Our Ref: EN020028

Date: 18 November 2024

Application by Morgan Offshore Wind Limited and Morecambe Offshore Windfarm Limited for an Order Granting Development Consent for the Morgan and Morecambe Offshore Wind Farms Transmission Assets project

Advice following issue of decision to accept the application for examination

Figure 1.5: Outline management of PRow within the Onshore Order Limits (Sheet 3)

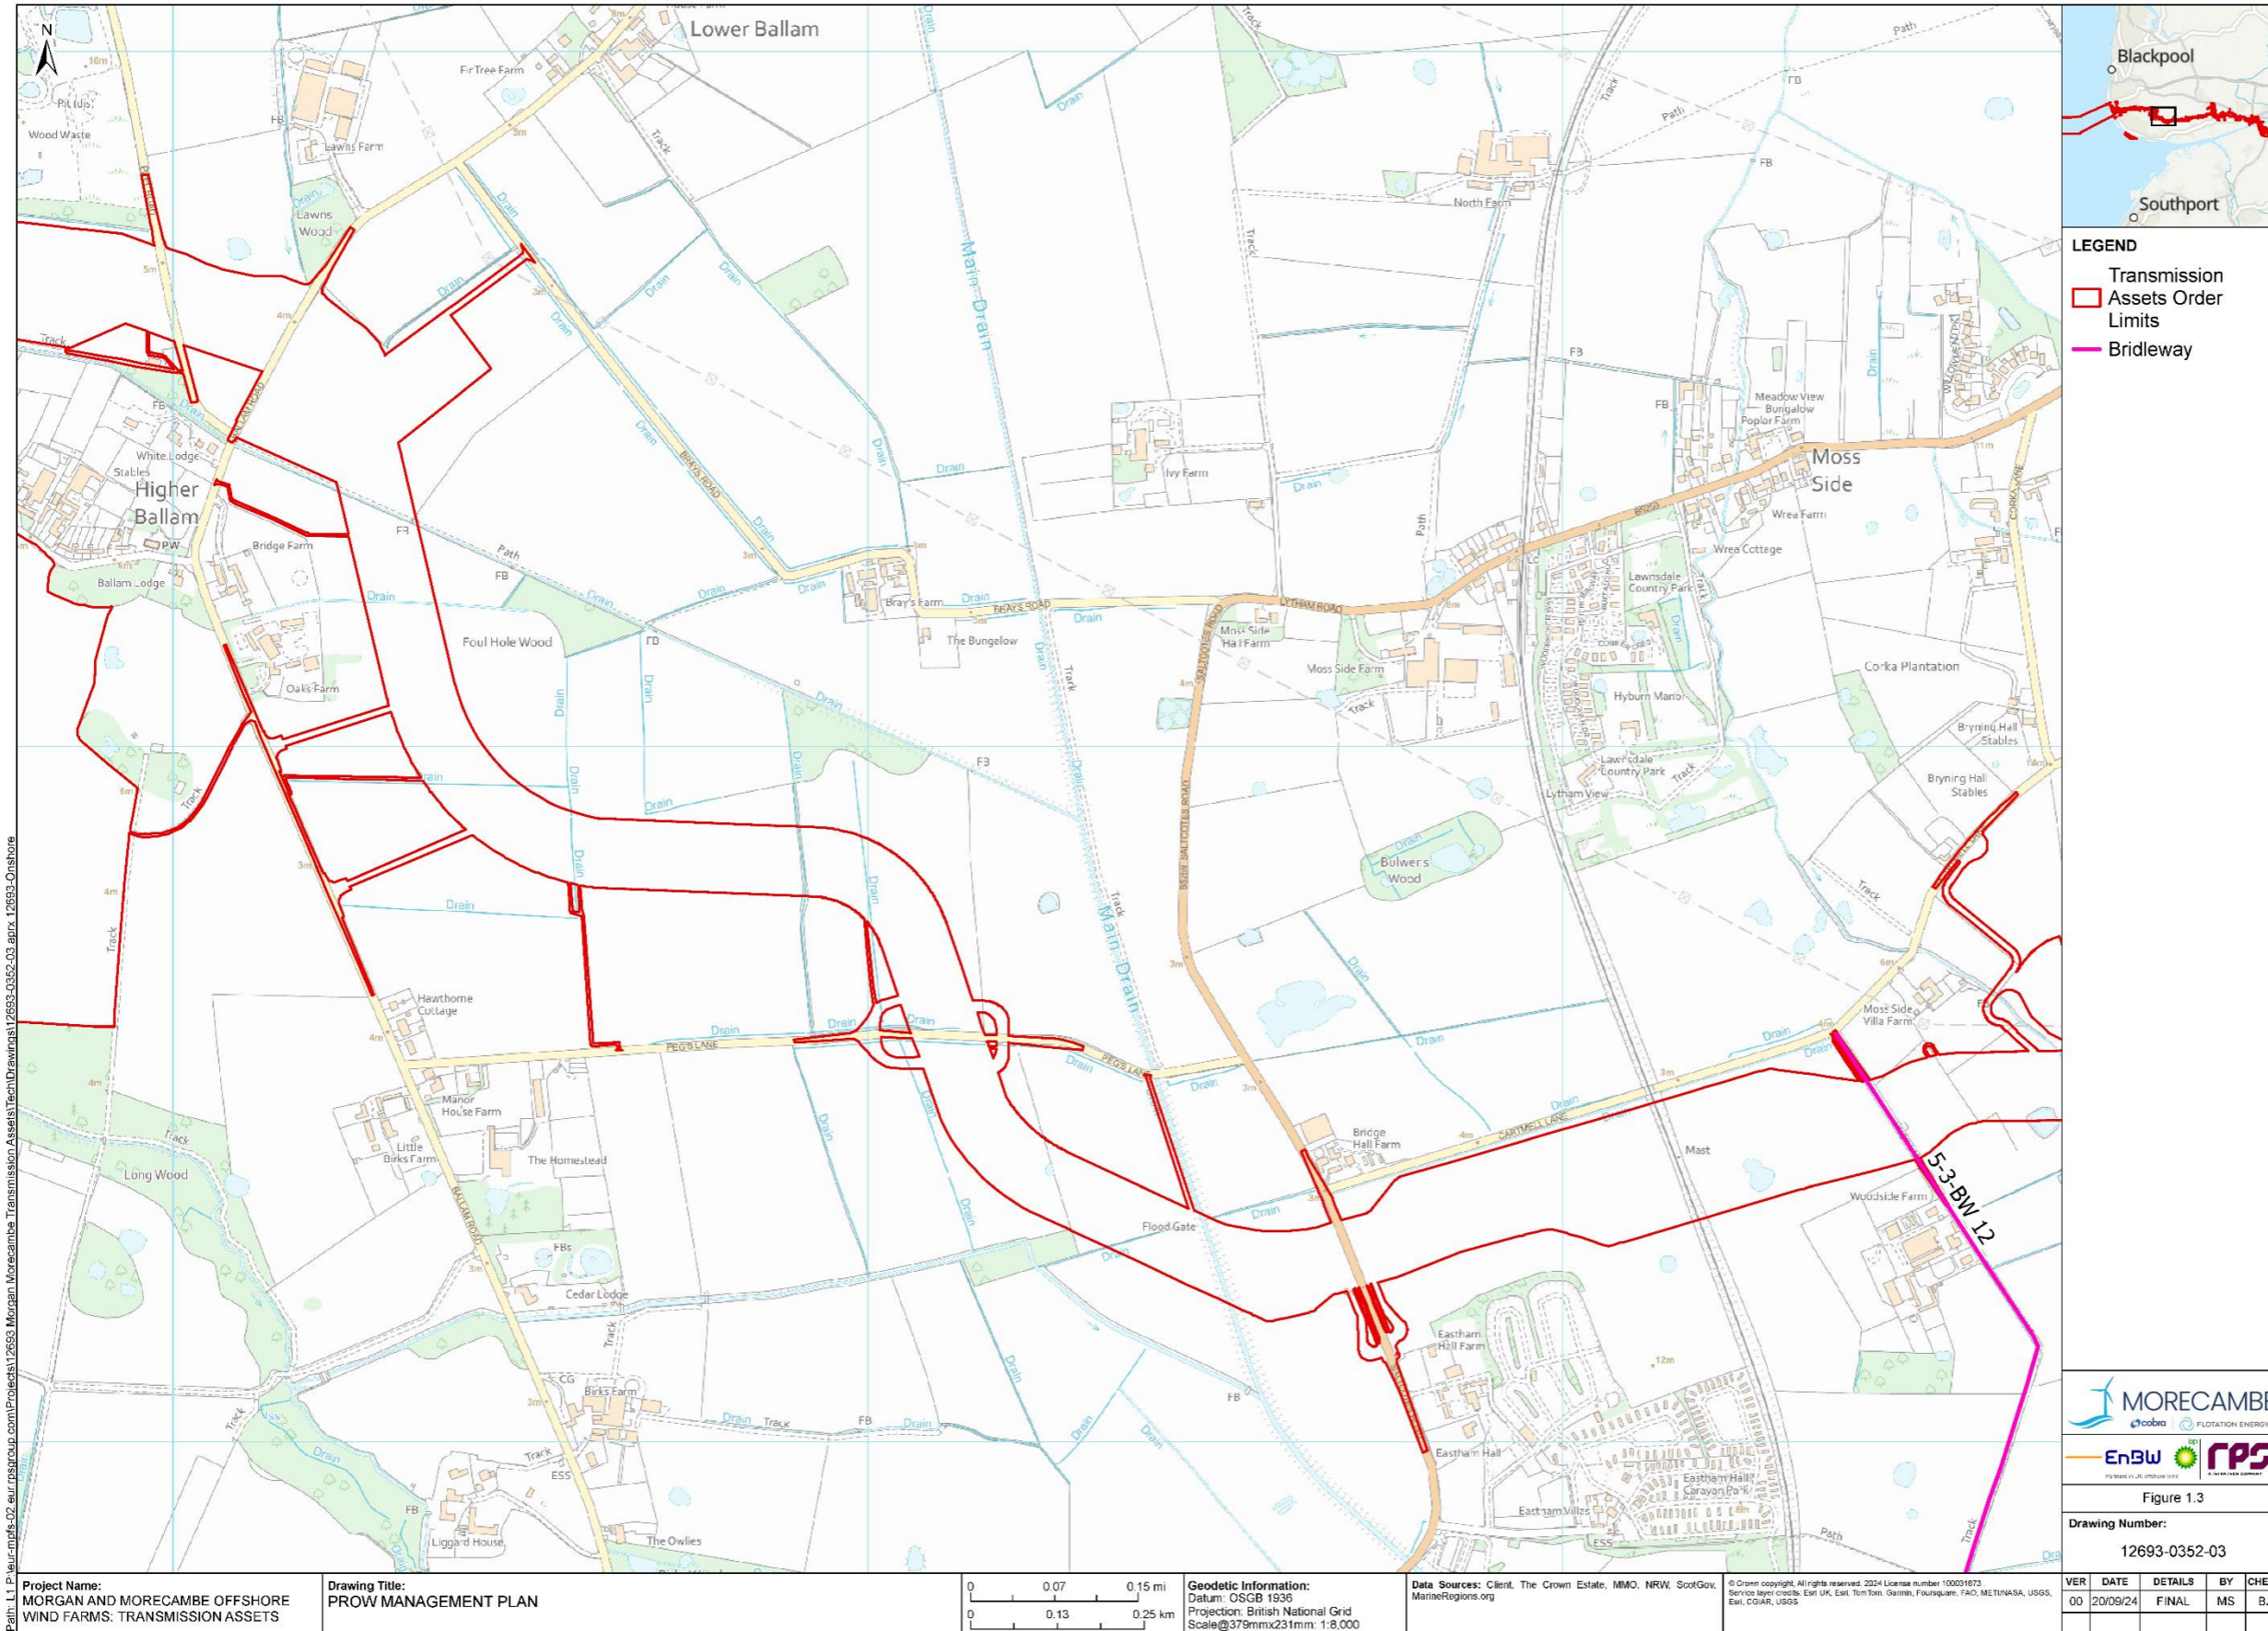
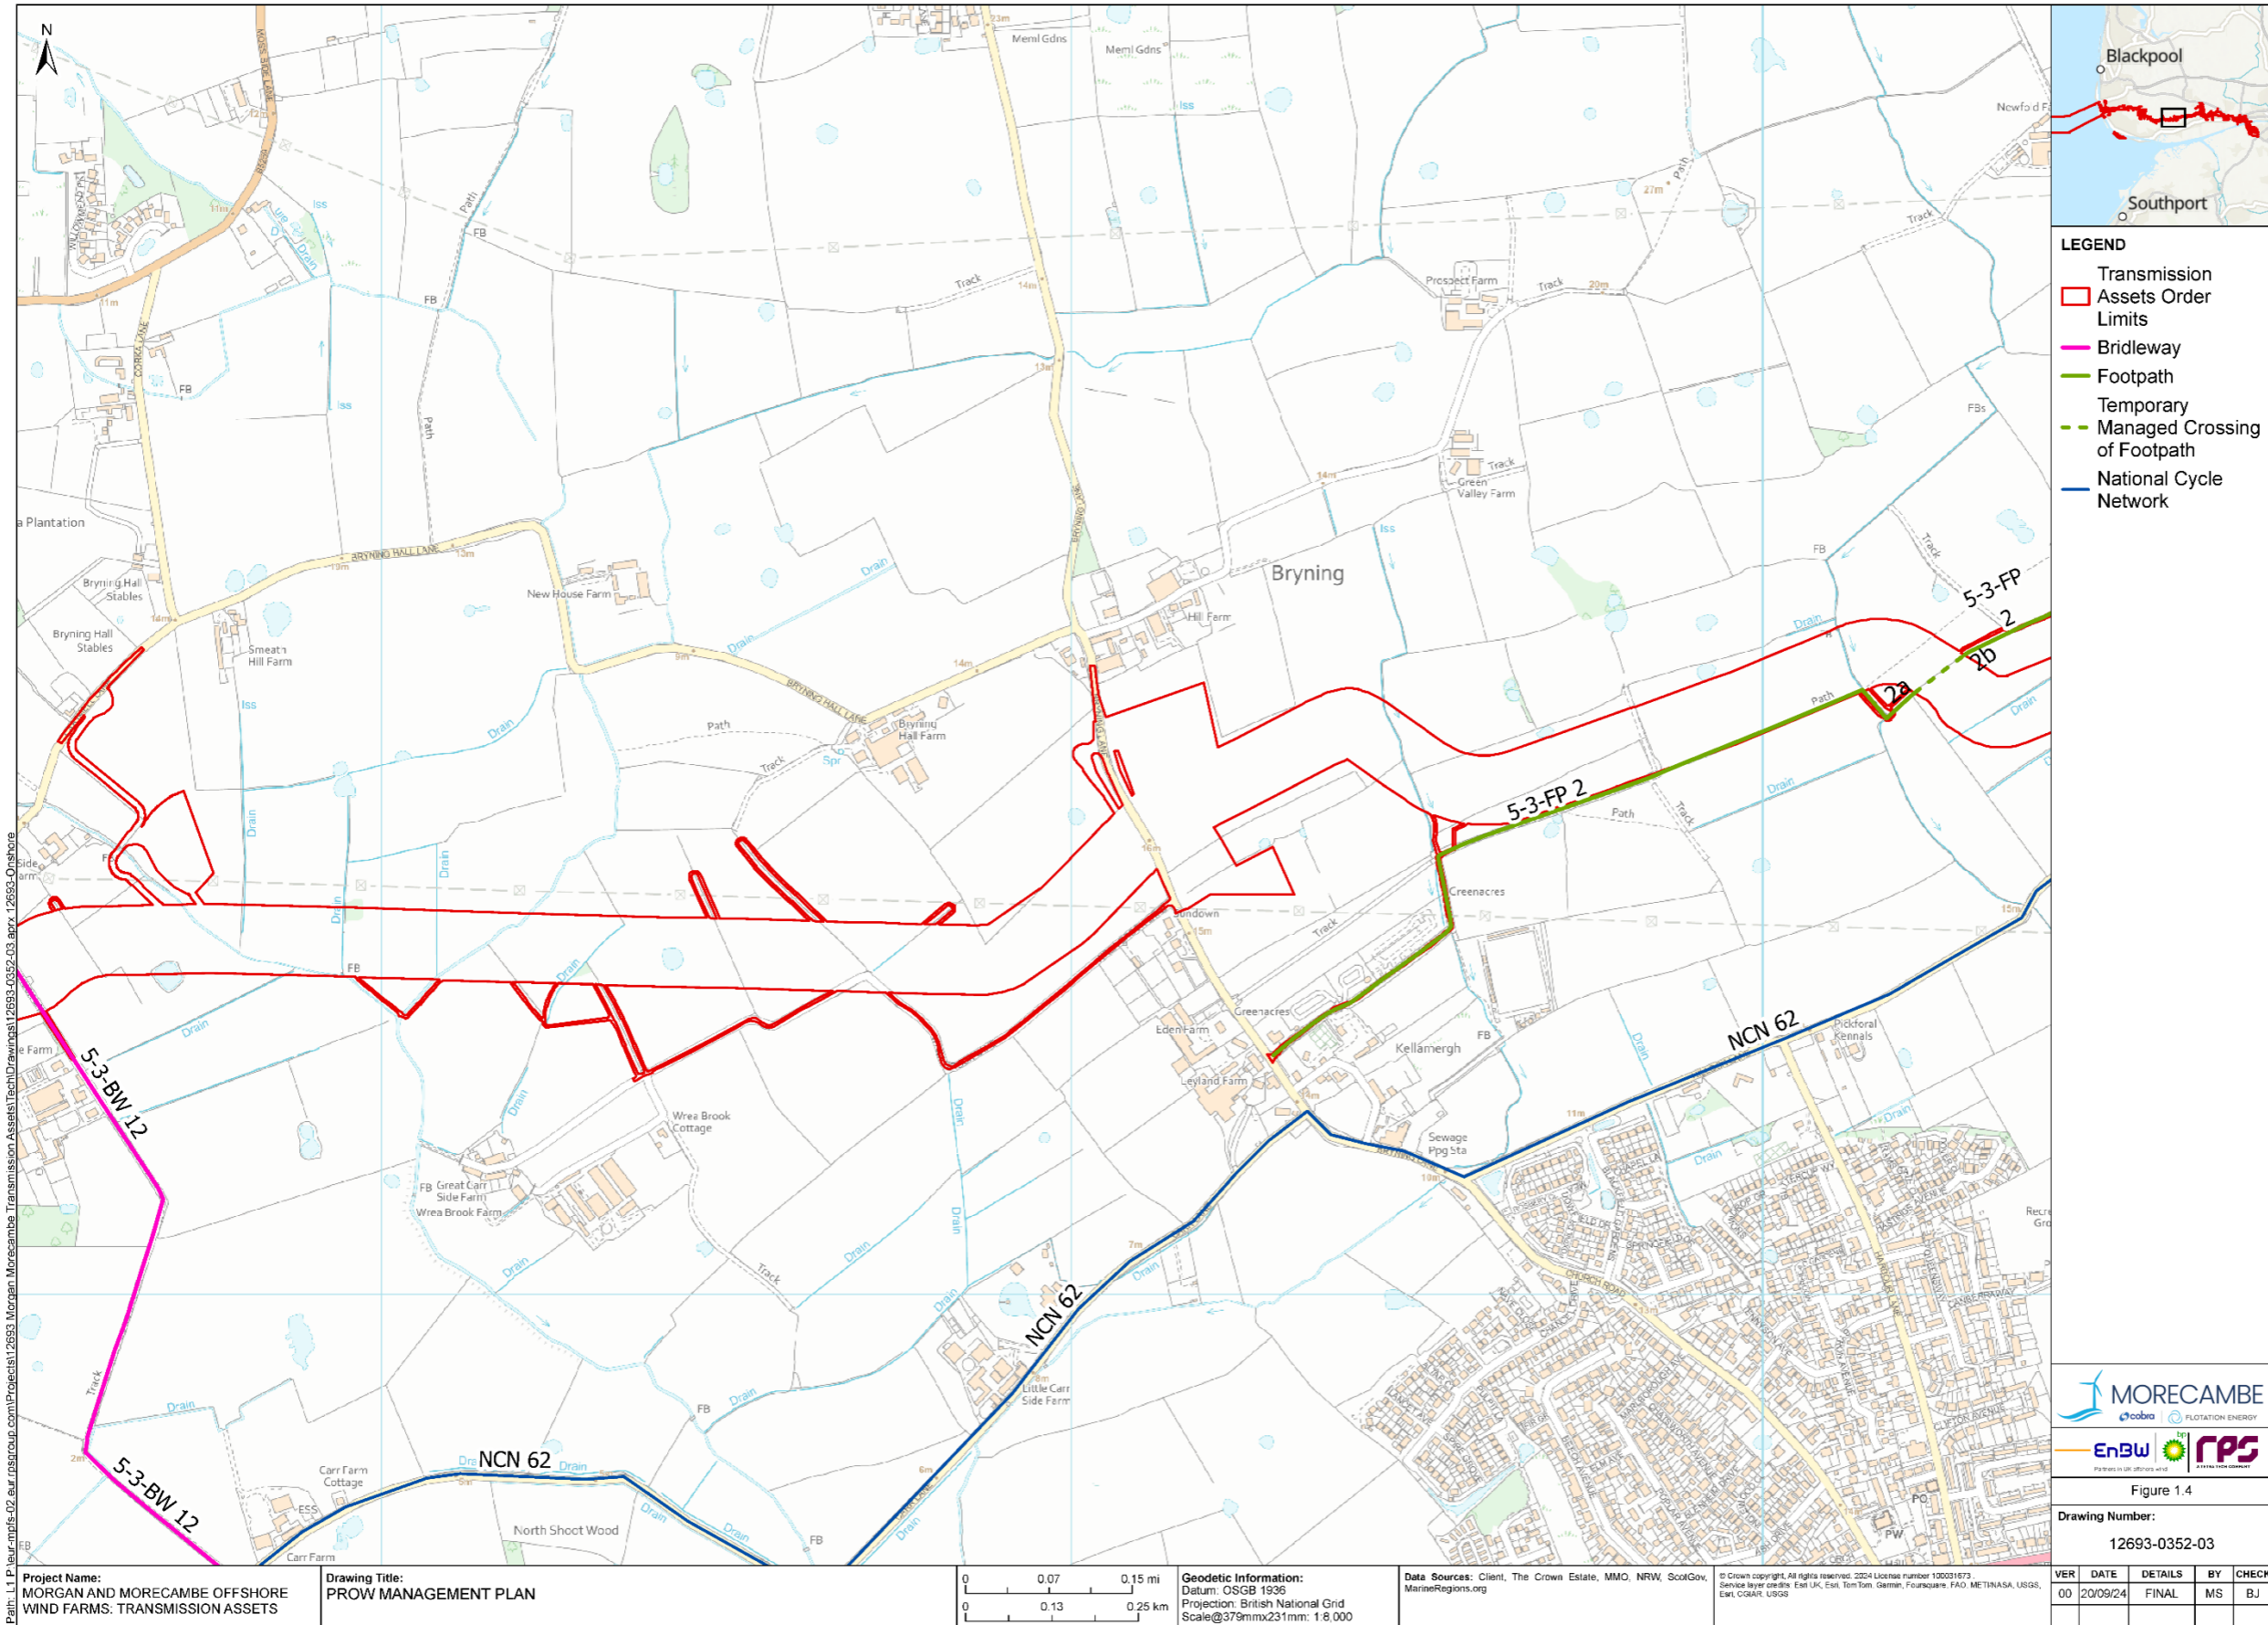
These plans should be reviewed for accuracy and readability, including how the keys/ledgers relate to the information portrayed on the plans.
